# DRB CASE ACTION LOG

DRB Application No.: **07DRB-70368**

Project # **1006931**

Project Name: **REGINA ADDITION**

**PLAT OF  
 LOTS 42-A & 43-A  
 REGINA ADDITION  
 PROJECTED SECTION 14, T. 10 N., R. 2 E., N.M.P.M.  
 TOWN OF ATRISCO GRANT  
 CITY OF ALBUQUERQUE  
 BERNALILLO COUNTY, NEW MEXICO  
 OCTOBER 2007  
 SHEET 2 OF 2**

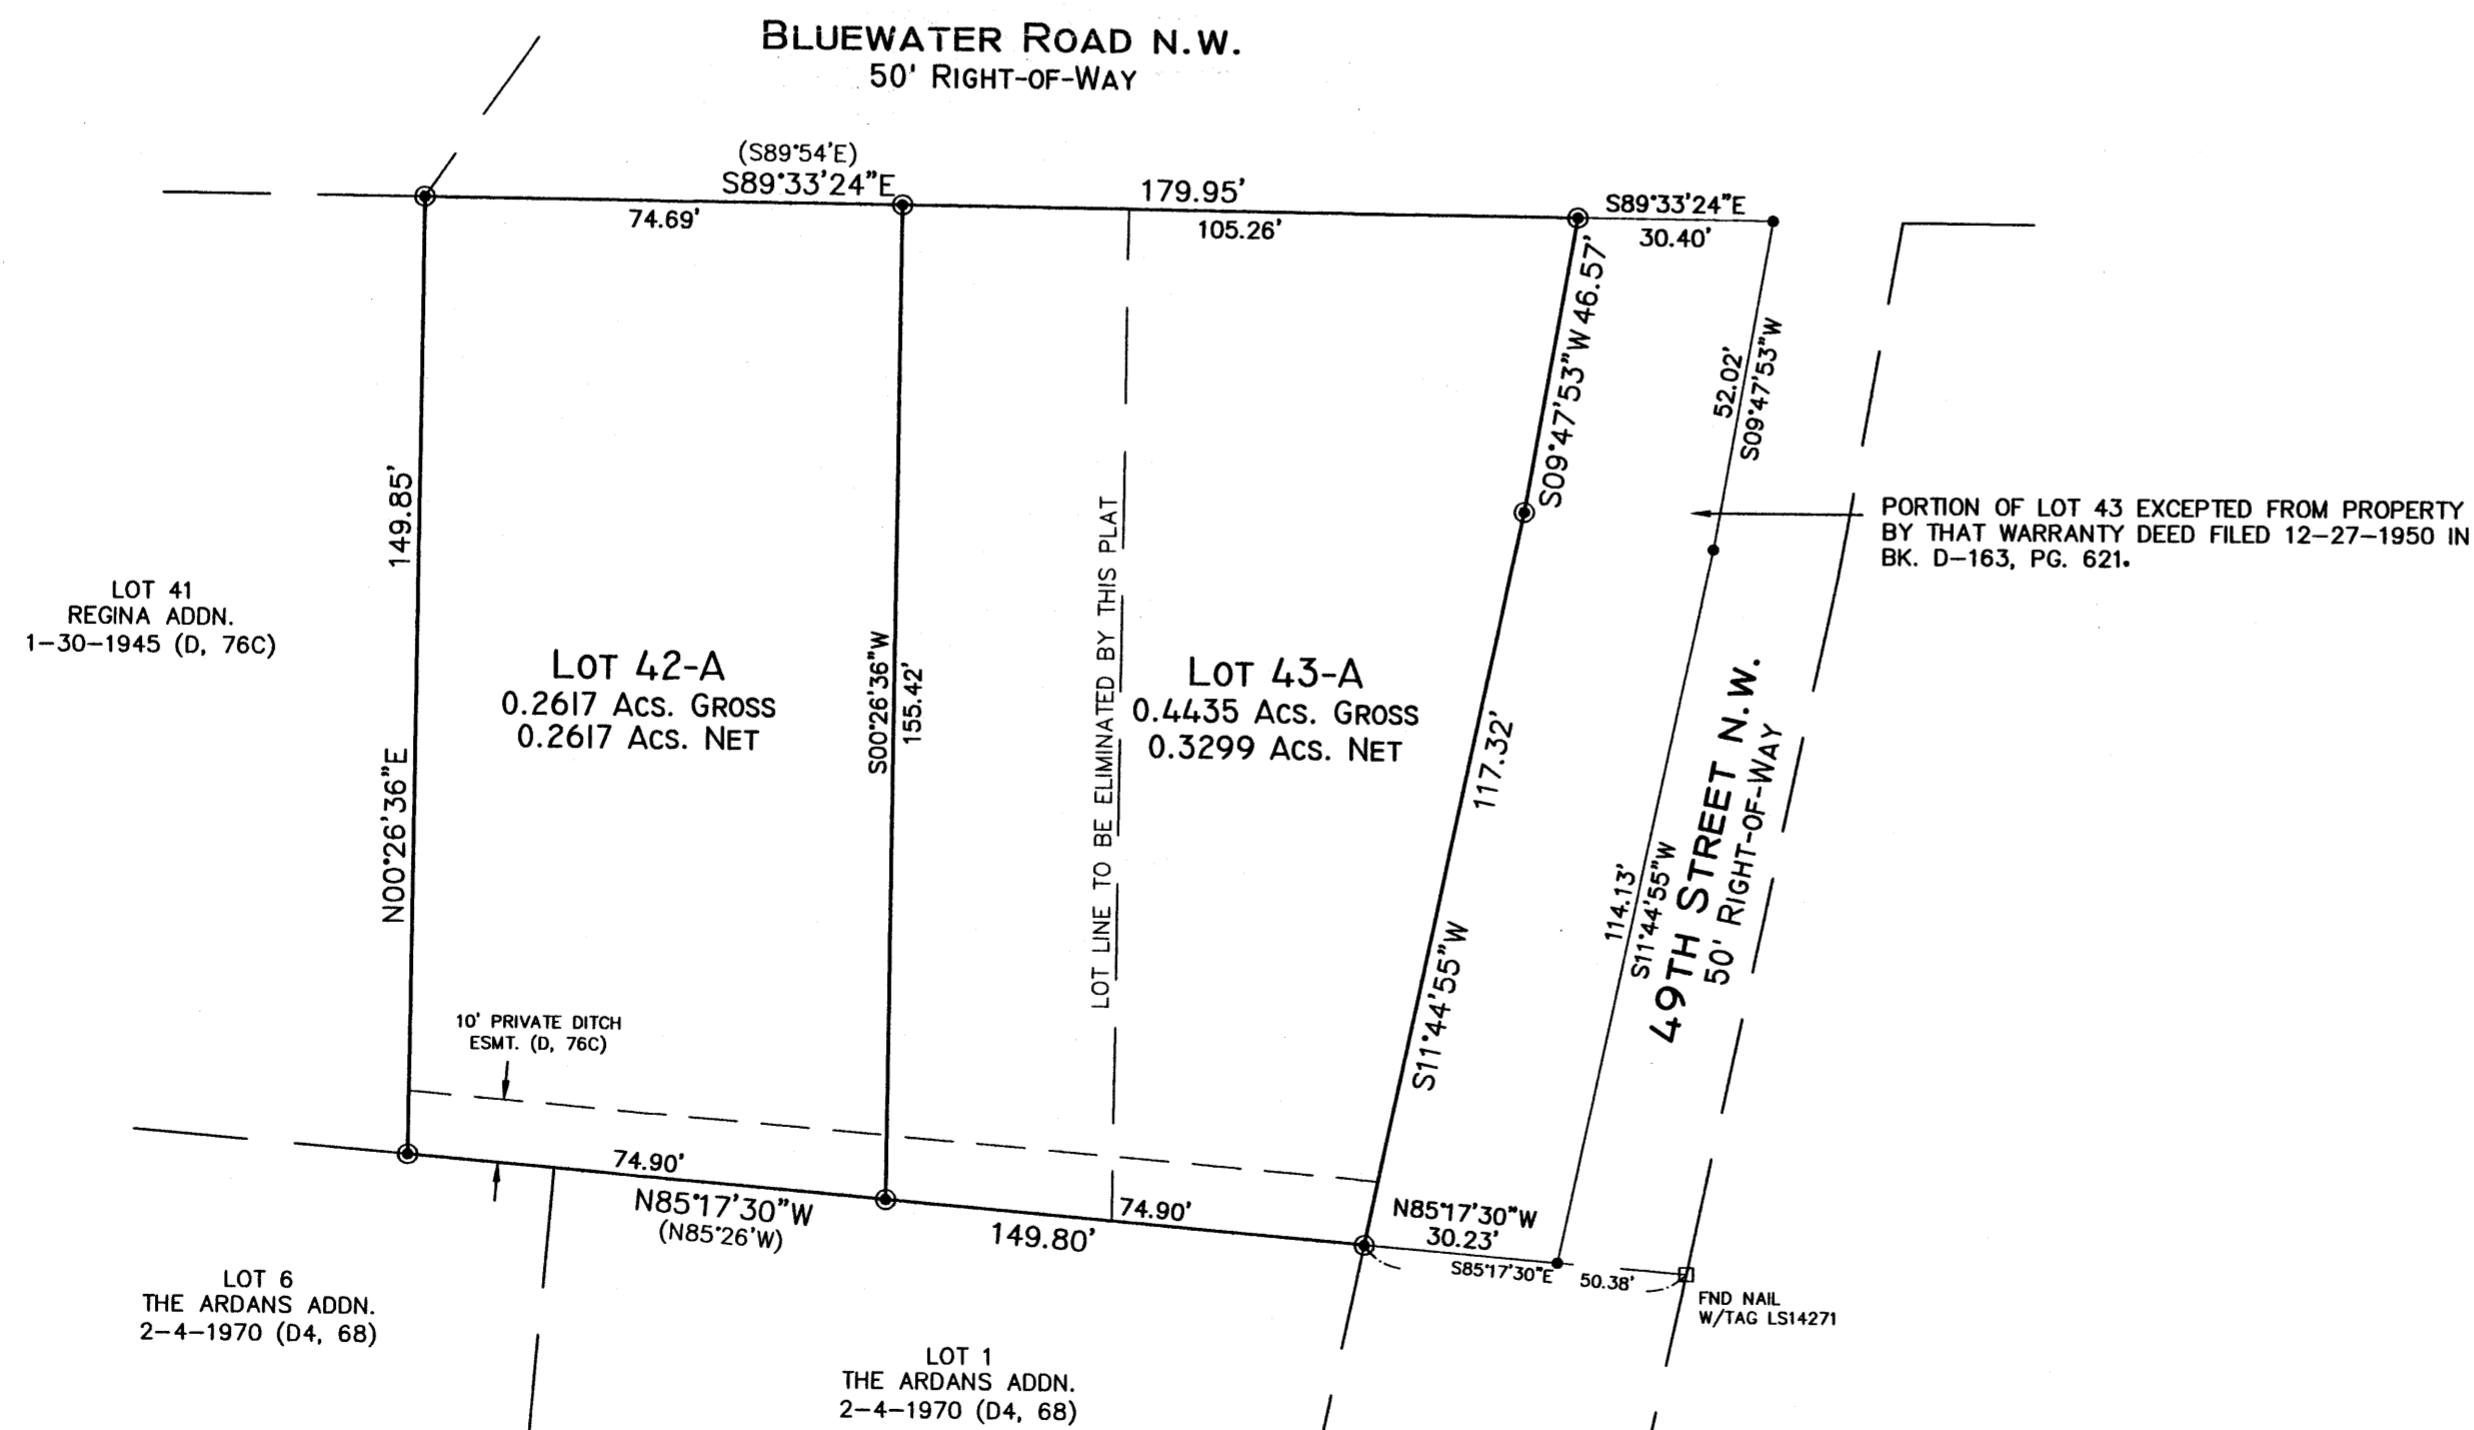
TRANSPORTATION: radius dedication

16. ~~Project# 1006931~~  
07DRB-70368 MINOR - PRELIMINARY/  
FINAL PLAT APPROVAL
- SURVEYS SOUTHWEST LTD agent(s) for JOSEPH LOVATO request(s) the above action(s) for all or a portion of Lot(s) 42 & 43, **REGINA ADDITION**, zoned R-1, located on BLUEWATER RD NW BETWEEN 49TH ST NW AND RINCON RD NW containing approximately 0.71 acre(s). (J-11) **THE PRELIMINARY PLAT WAS APPROVED WITH FINAL SIGN OFF DELEGATED TO PLANNING FOR AGIS DXF AND TO TRANSPORTATION FOR 20 FT RADIUS AT RIGHT-OF-WAY DEDICATION.**
